Response to Submissions

Waterloo Metro Quarter – Northern Precinct (SSD-79307758)

March 2026

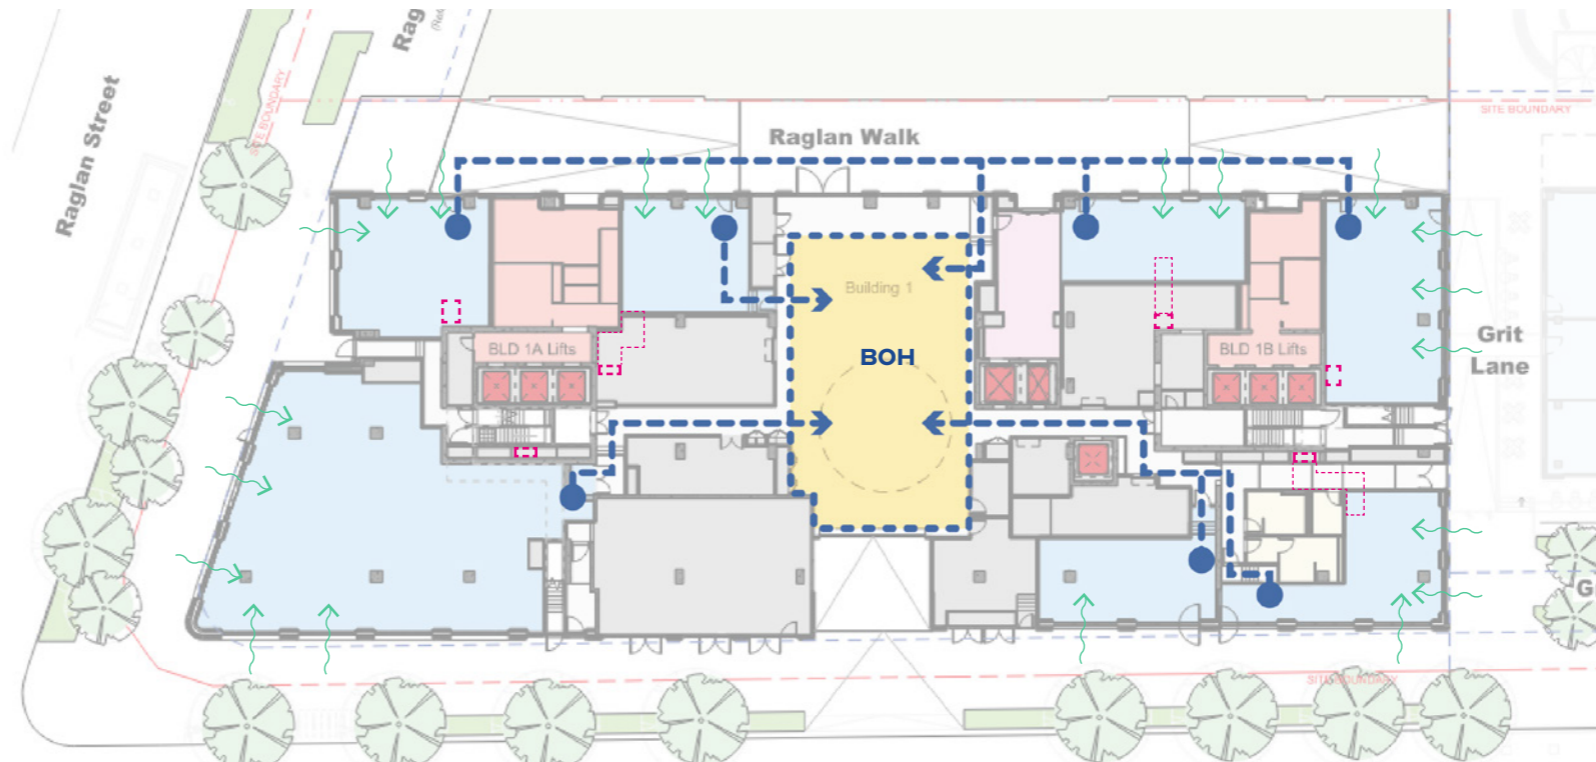
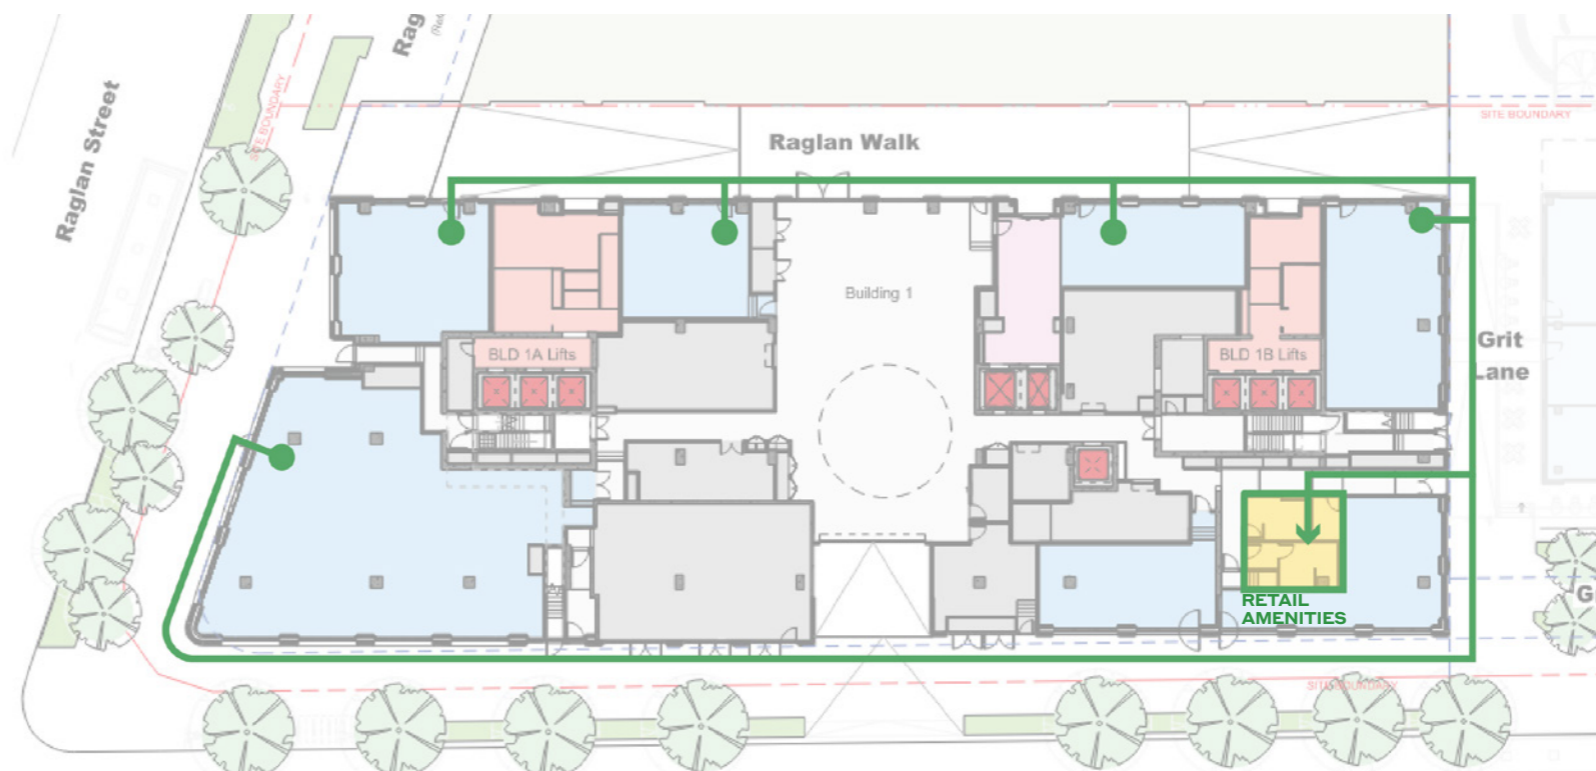
Address SDRP advice on Site Strategy and Built Form Point 8: Ensure that the serviceability of the retail offerings is considered during design development. For example, access to shared amenities, ventilation requirements and kitchen exhausts

Access to the northern precinct retail amenities is via Grit Lane, where food and beverage tenancies are located in close proximity, providing convenient access for patrons. The central precinct has its own dedicated shared amenities to service retail tenancies located in the central precinct. All retail units are equipped with adequate ventilation, with kitchen exhausts provided to all units except Retail 7, as it is not intended to be a food and beverage premises.

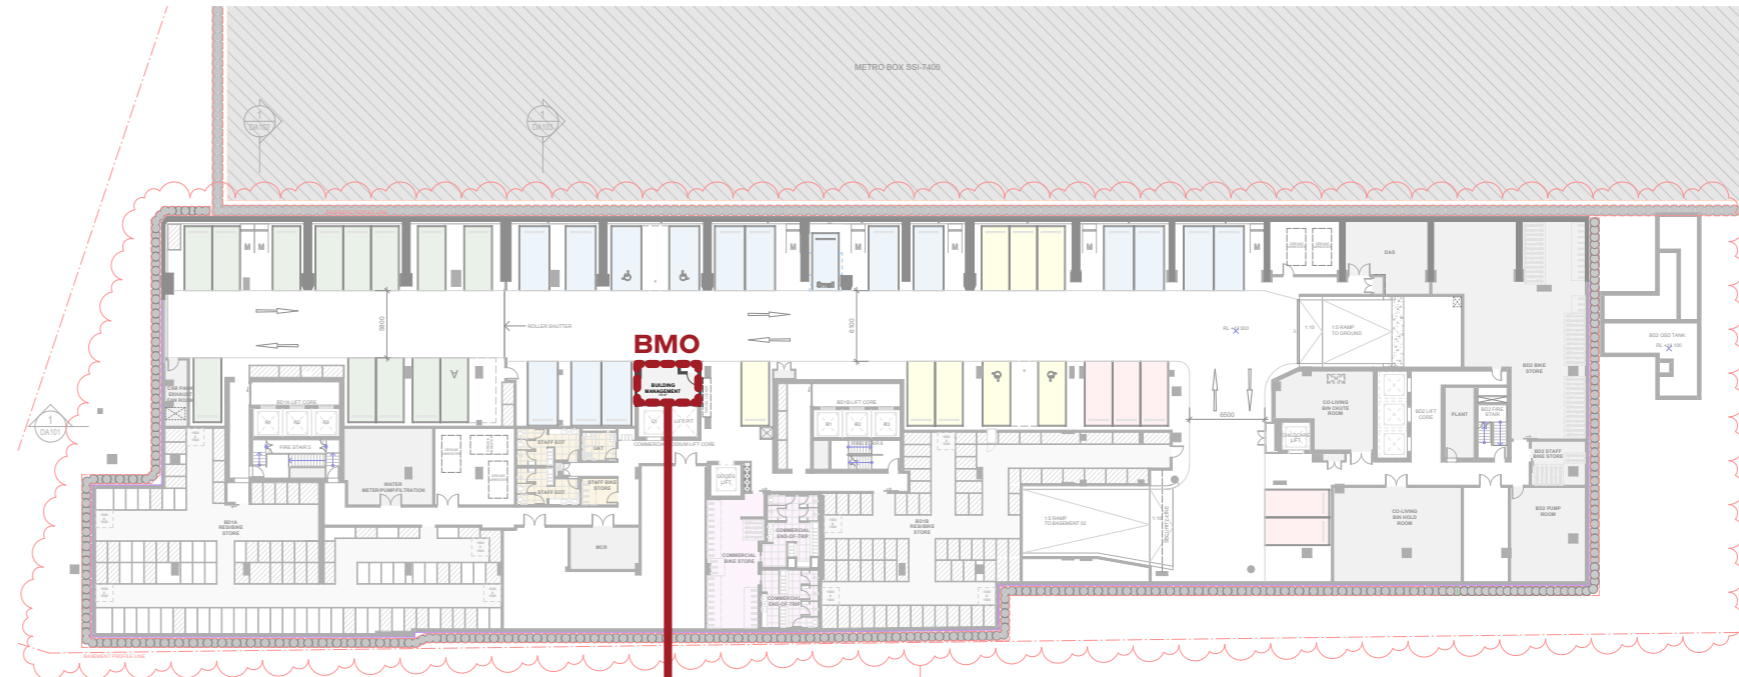
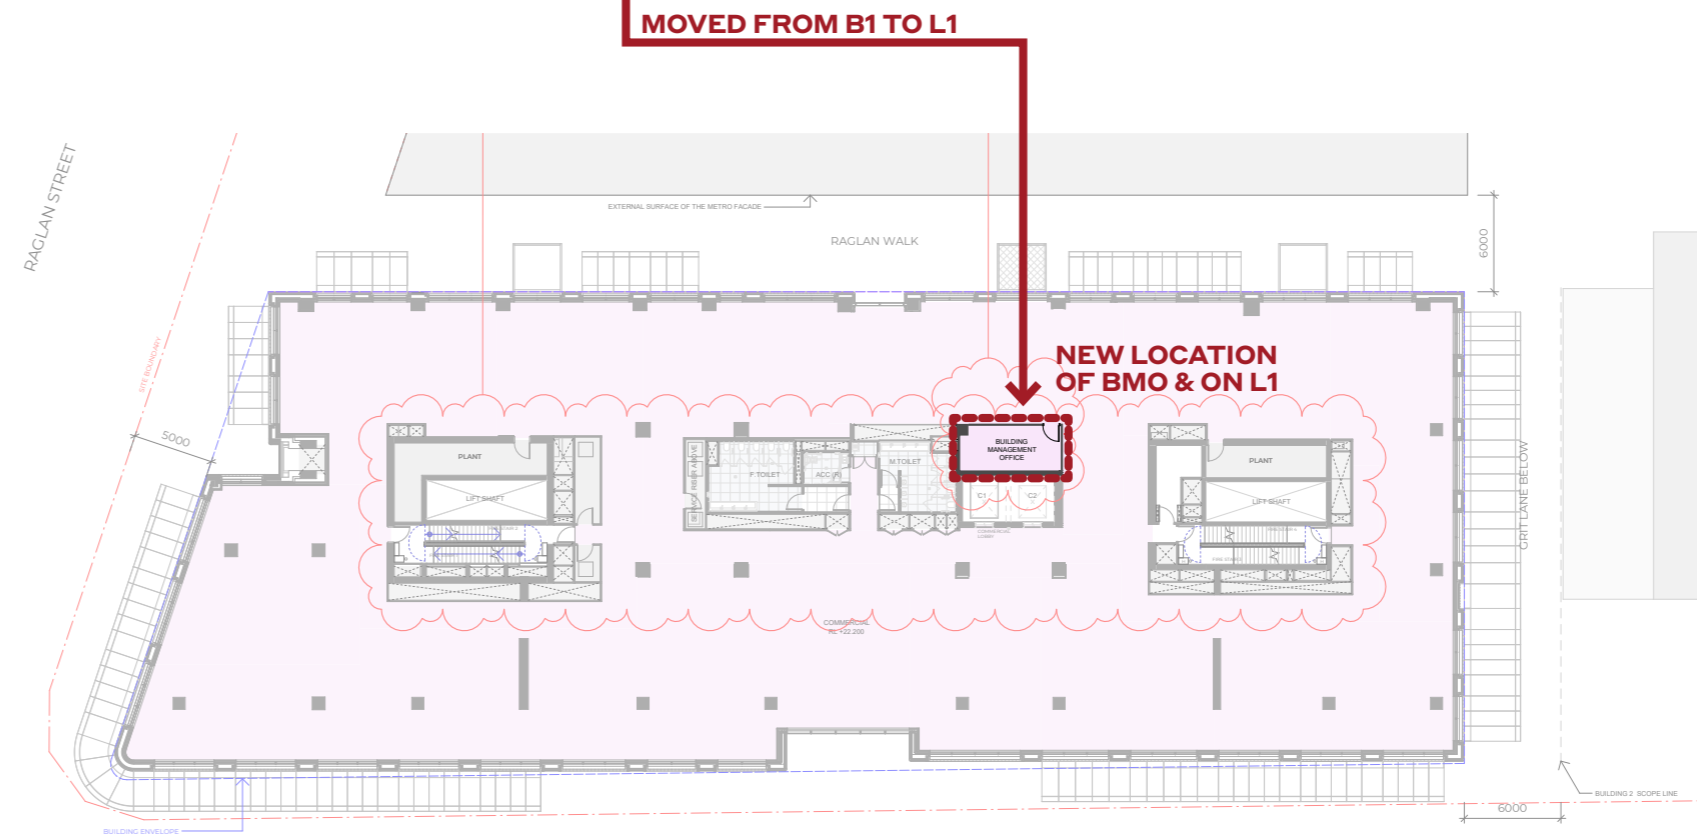
- a) Review the flood planning levels with climate change sensitivity analysis for the Northern Precinct either by applying freeboard to the retail floor levels, or alternatively using the latest methodologies in the Australian Rainfall and Runoff Guidebook to develop more accurate estimates of changes to flood levels under climate change conditions
- b) Relocate the habitable use (building management office) from the basement
- c) Demonstrate how occupants of the Central Precinct south-western retail area could feasibly relocate to higher levels considering available warning time and mechanisms to provide warnings

The Supplementary Design Report details that the building management office has been relocated from the basement to Level 1.

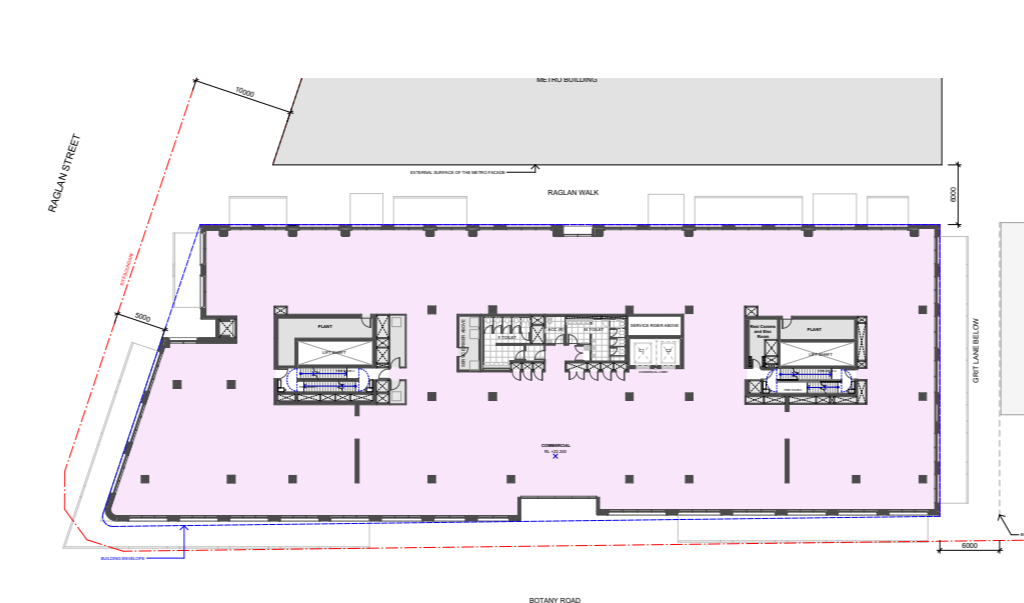
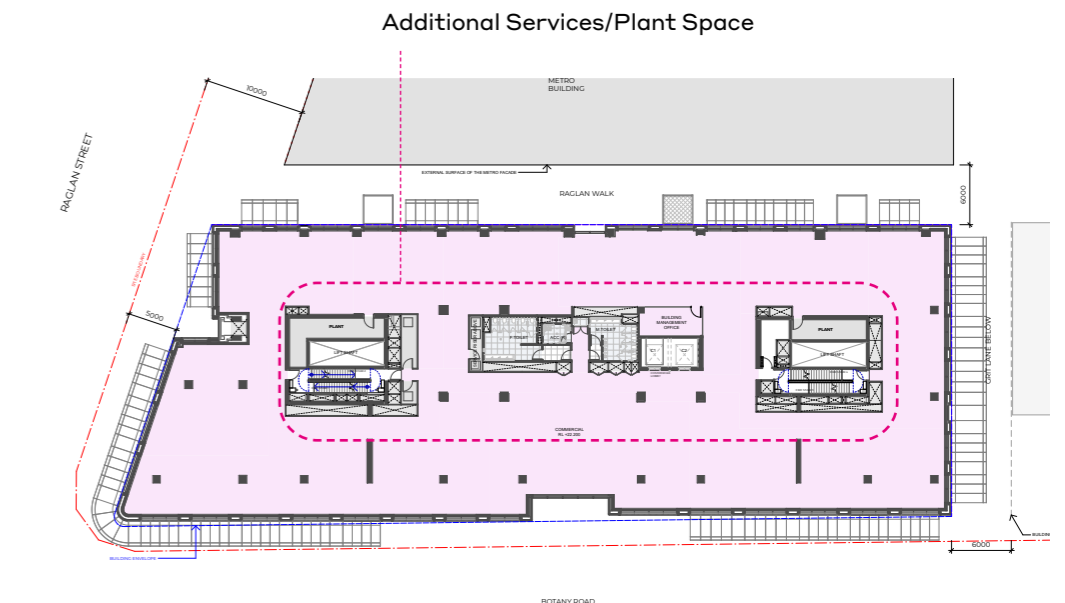
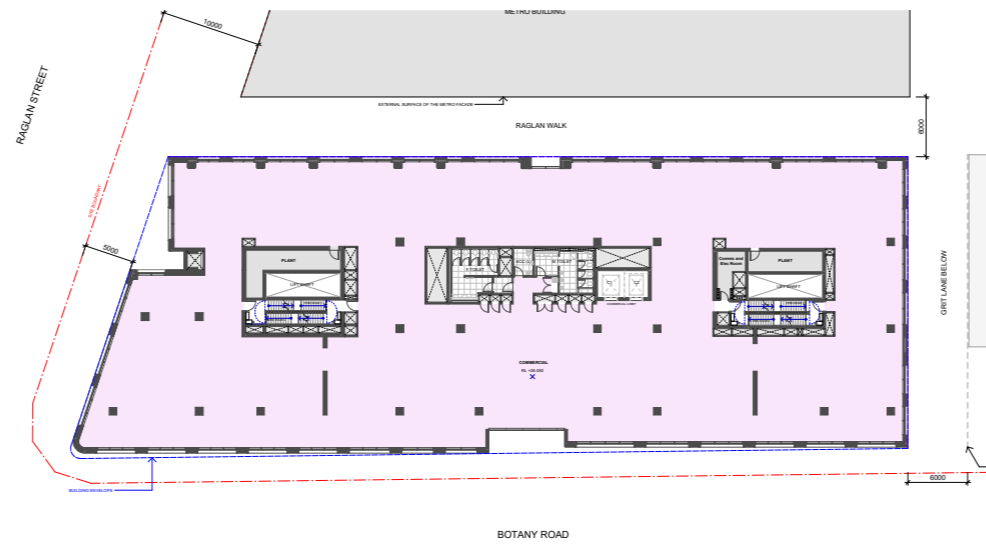
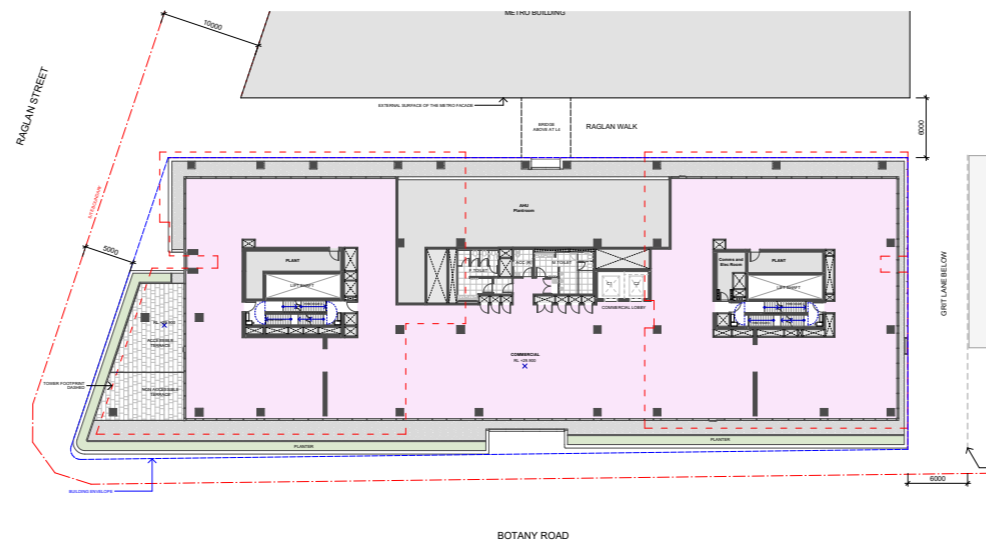
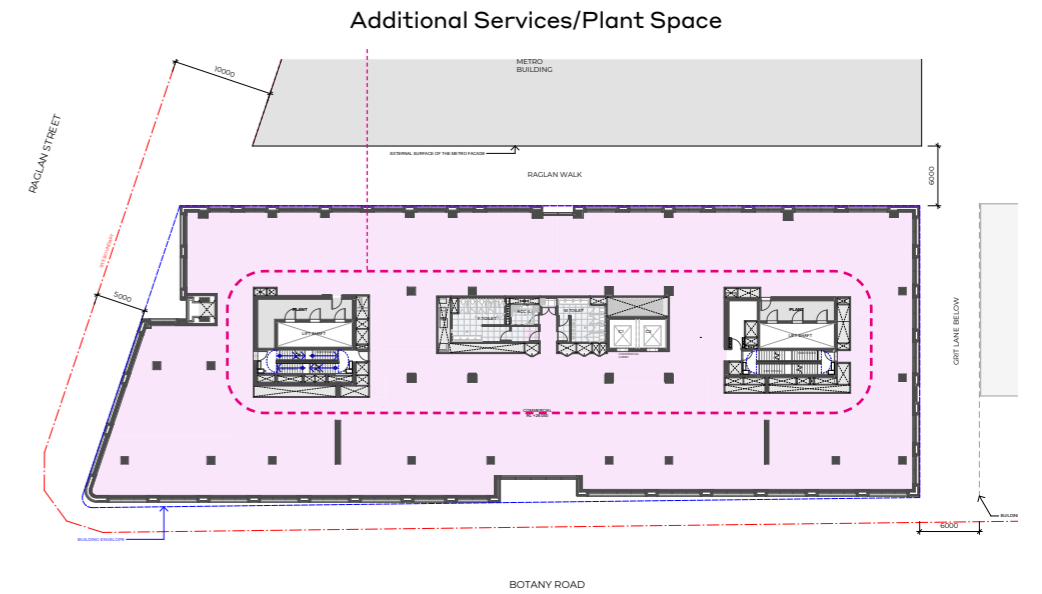
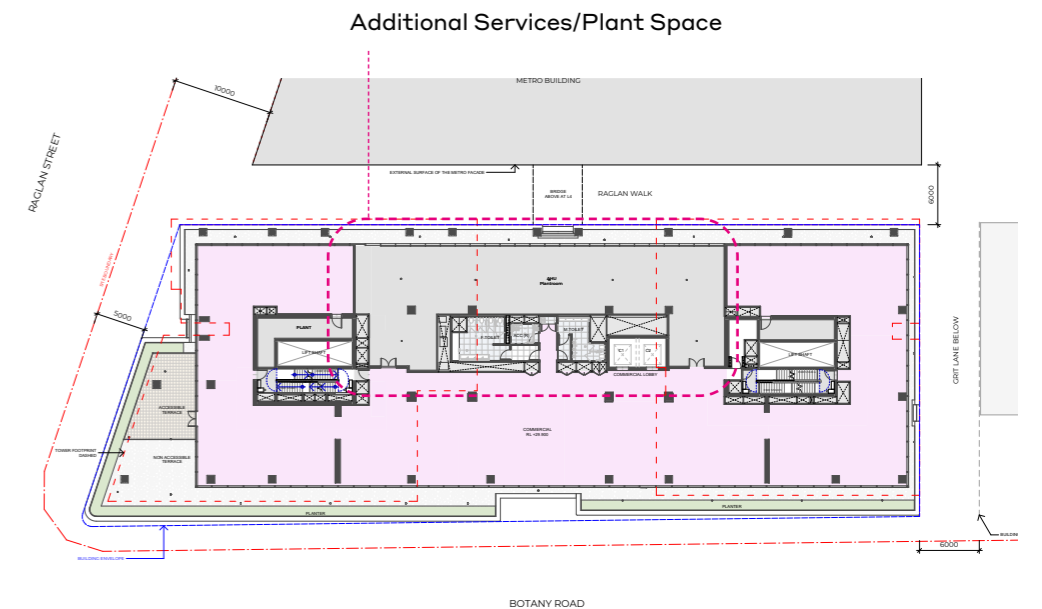
b) Provide a revised Clause 4.6 Statement addressing the objective of Sydney LEP section 6.45(1)(a) in respect to the variation of the minimum non-residential floorspace standard.	The change to the non-residential GFA is a result of ongoing design development, which includes the additional plant and riser spaces now required. A revised The design refinements to the northern precinct have resulted in a minor additional reduction to the non-residential GFA, by	Appendix B – Supplementary Design Report Appendix K – Updated Clause 4.6 Request

approximately 8sqm, due to the increase in riser size to all commercial levels and plantroom on Level 3. A Revised Clause 4.6 has been prepared (refer to Appendix K) to reflect the proposed variation.

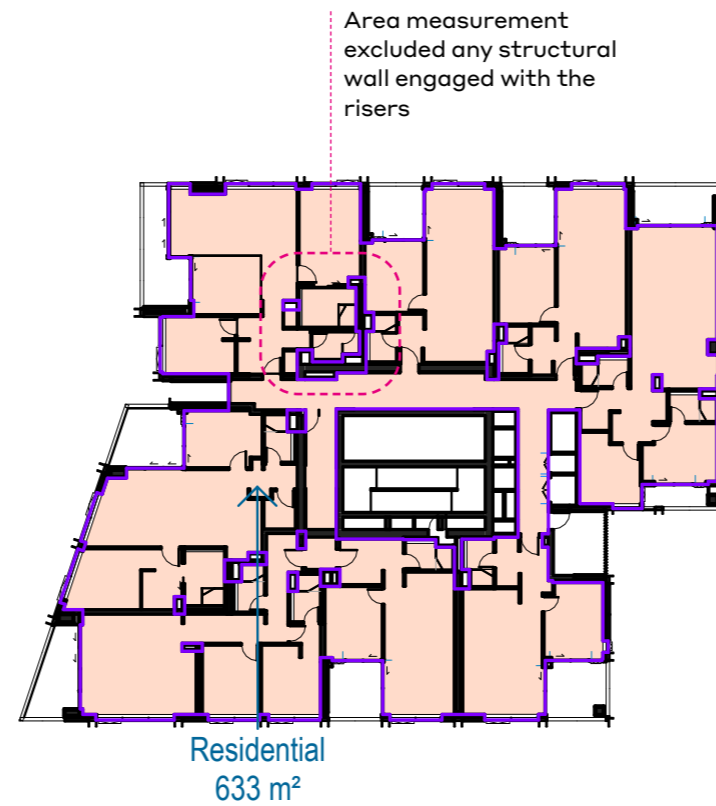
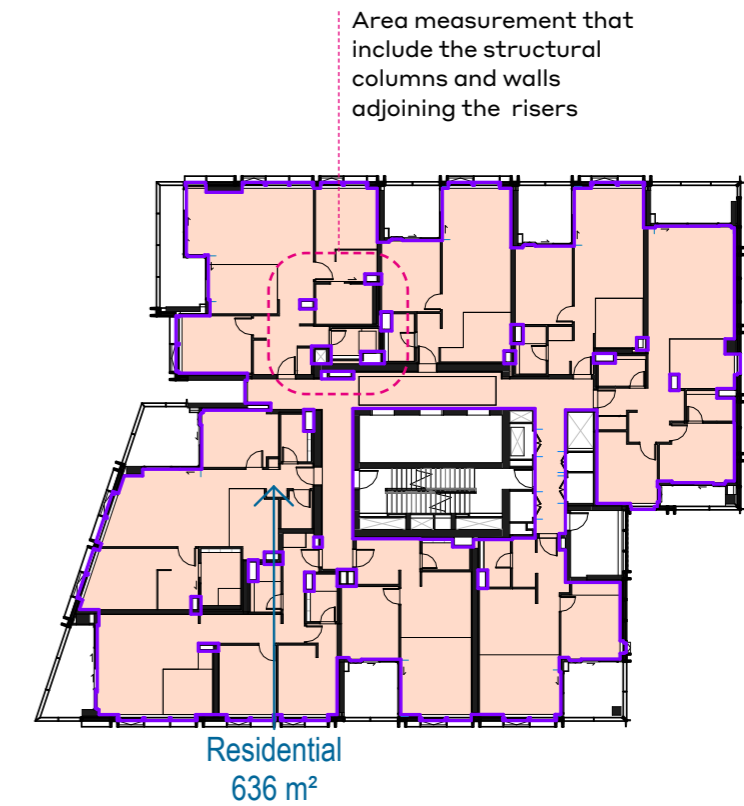
- Relocating the building office managers office from the basement to the Level 1 to address flooding impacts.
- Increase in riser size to all commercial levels and plantroom on Level 3, reducing the non-residential GFA by approximately 8 sqm.
- A minor adjustment to the residential GFA (+41 sqm) following a review of the measurement methodology with the surveyor. While service risers can be excluded from GFA, the surveyor confirmed that the adjoining structural columns and walls must be included. The residential GFA has therefore been adjusted to reflect this.
